CITY OF ALBUQUERQUE

**RE: Lot 5 Block 9 SAD 228 Volcano Cliffs
6428 Picardia NW
Grading and Drainage Plan
Engineers Stamp Date 8/8/18 (D10D003Q5)
Pad Certification Dated 10/8/18**

ENGINEER'S SEAL	LOT 5, BK 9 UN 22 VOLCANO CLIFFS 6428 PICARDIA PLACE	DRAWN BY DEM
DAVID SOULE REGISTERED PROFESSIONAL ENGINEER 14522	GRADING AND DRAINAGE PLAN	DATE 8-7-18
	 1606 CENTRAL AVENUE SE SUITE 201 ALBUQUERQUE, NM 87106 (505) 872-0289	SHEET # C1
8/8/18		JOB #
DAVID SOULE P.E. #14522

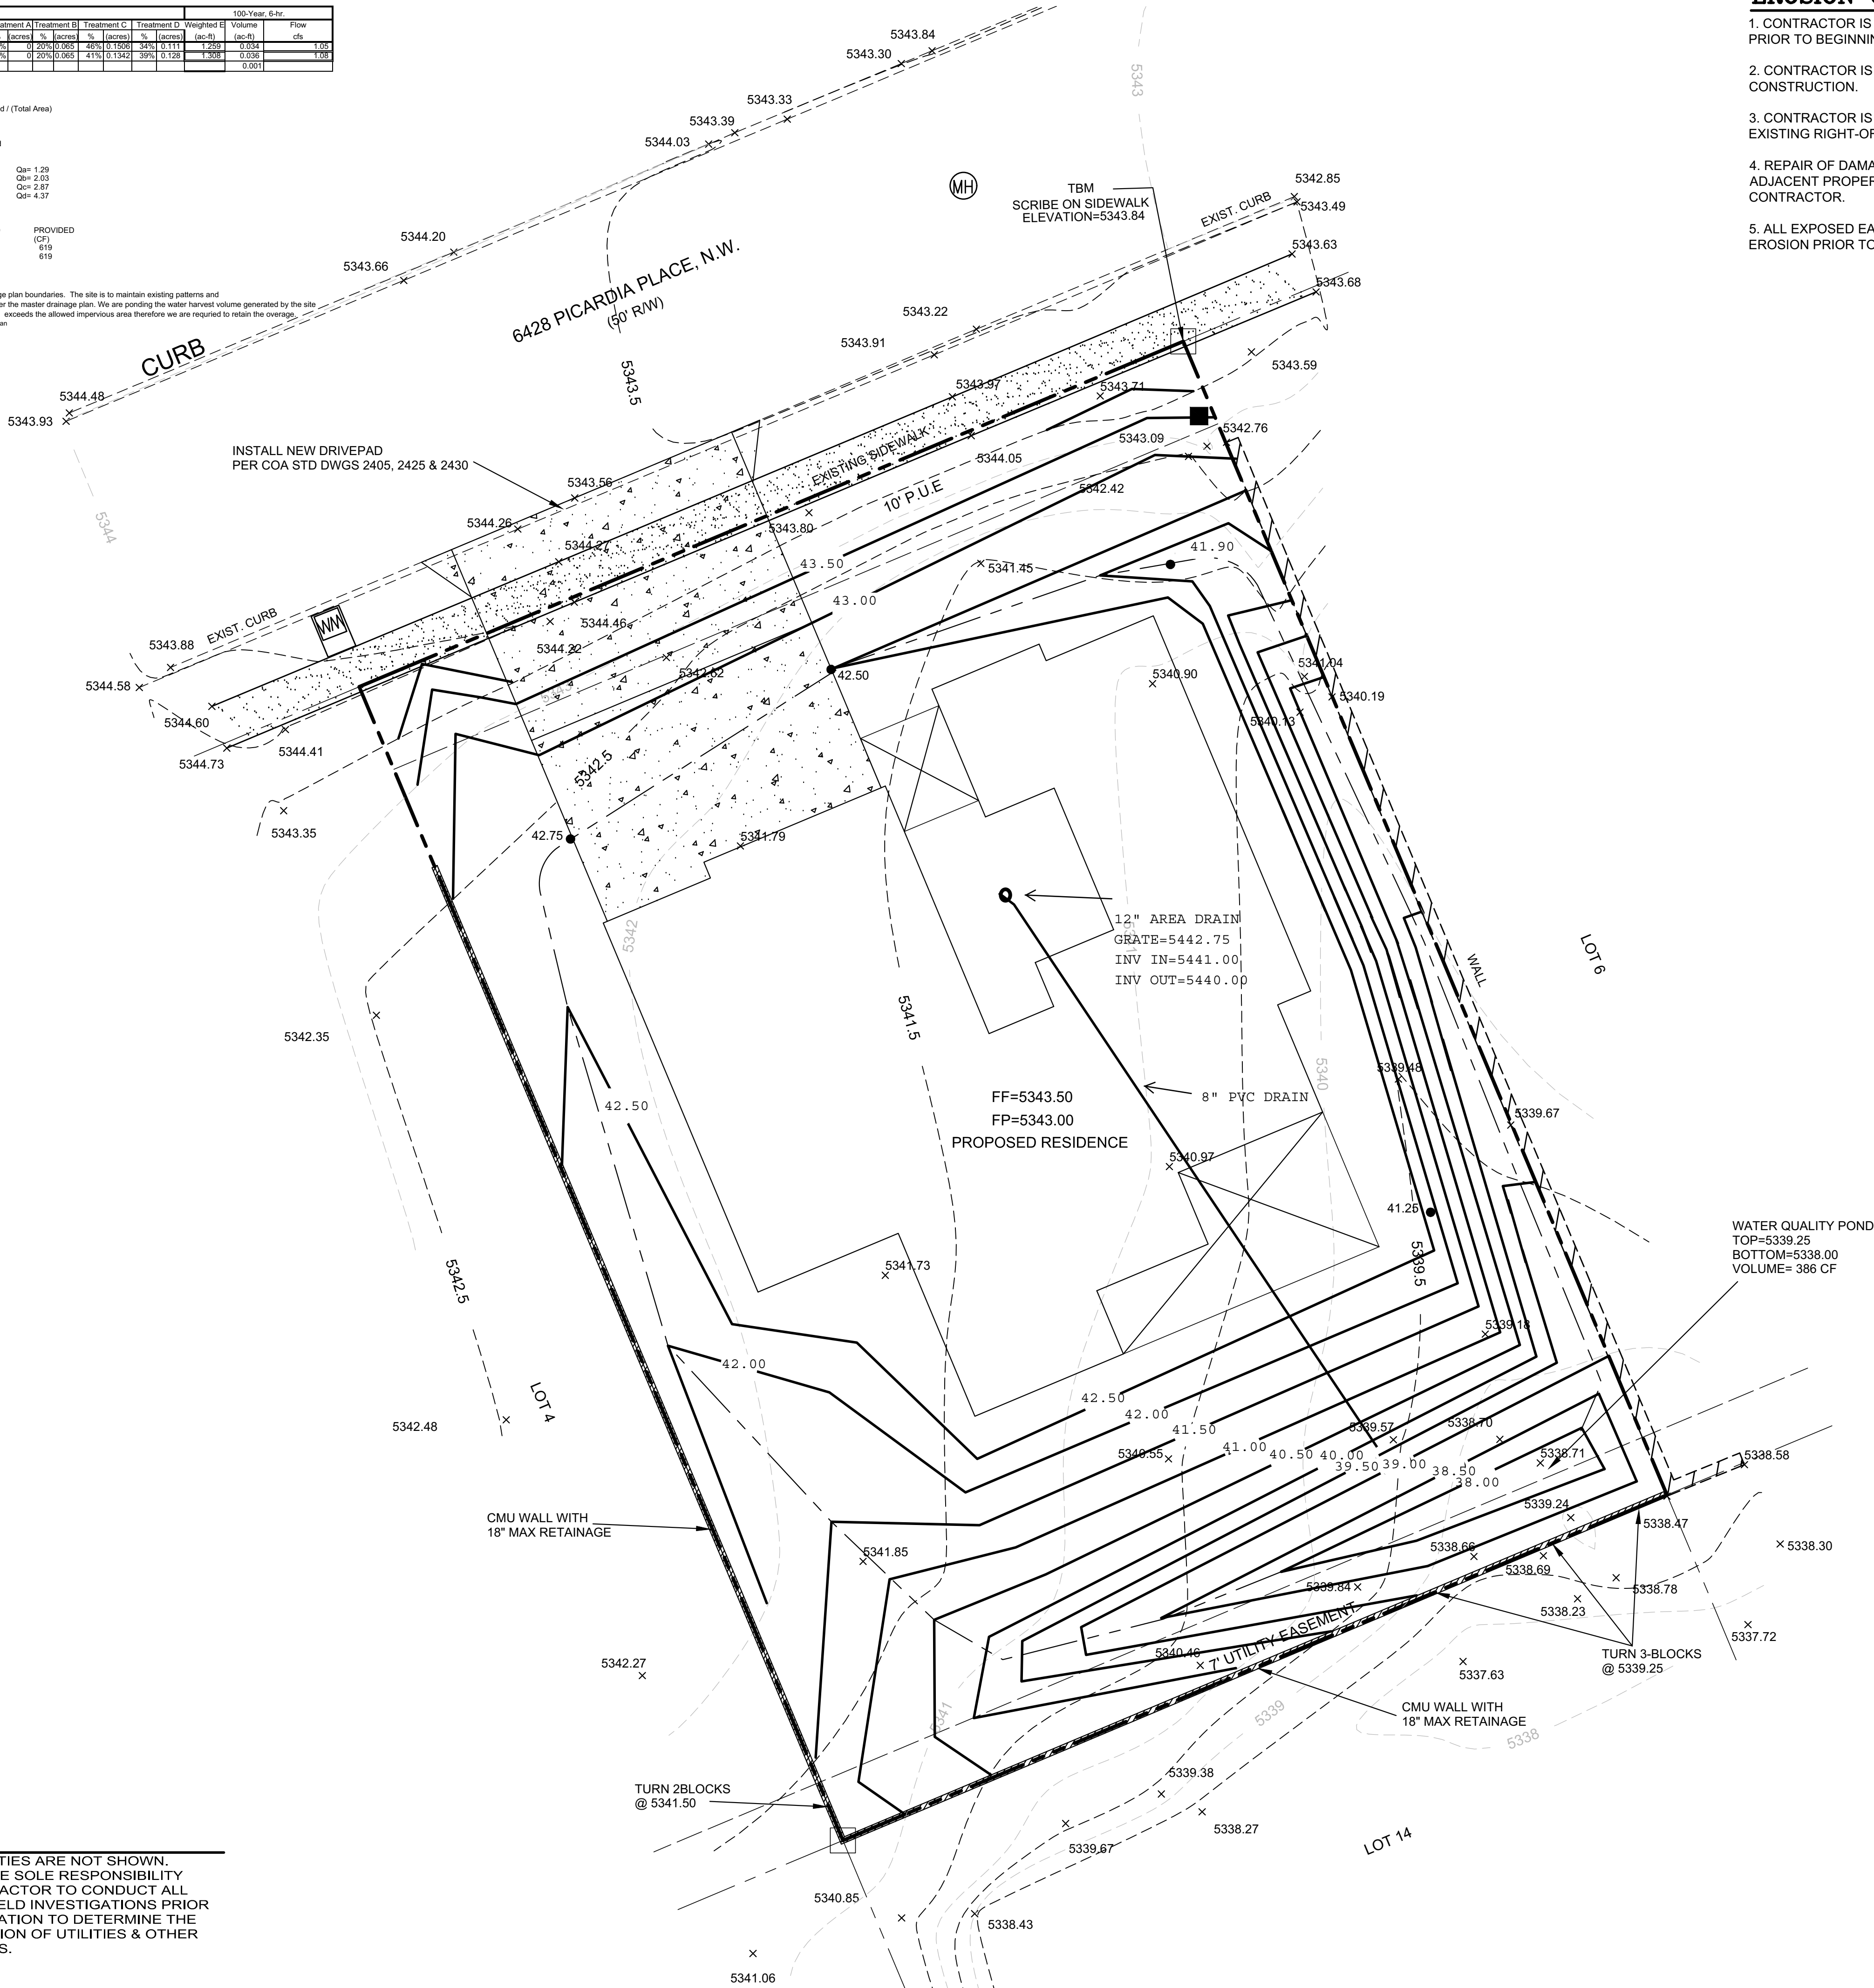
- Remove the dirt from Picardia St, the sidewalk and the mow strip.
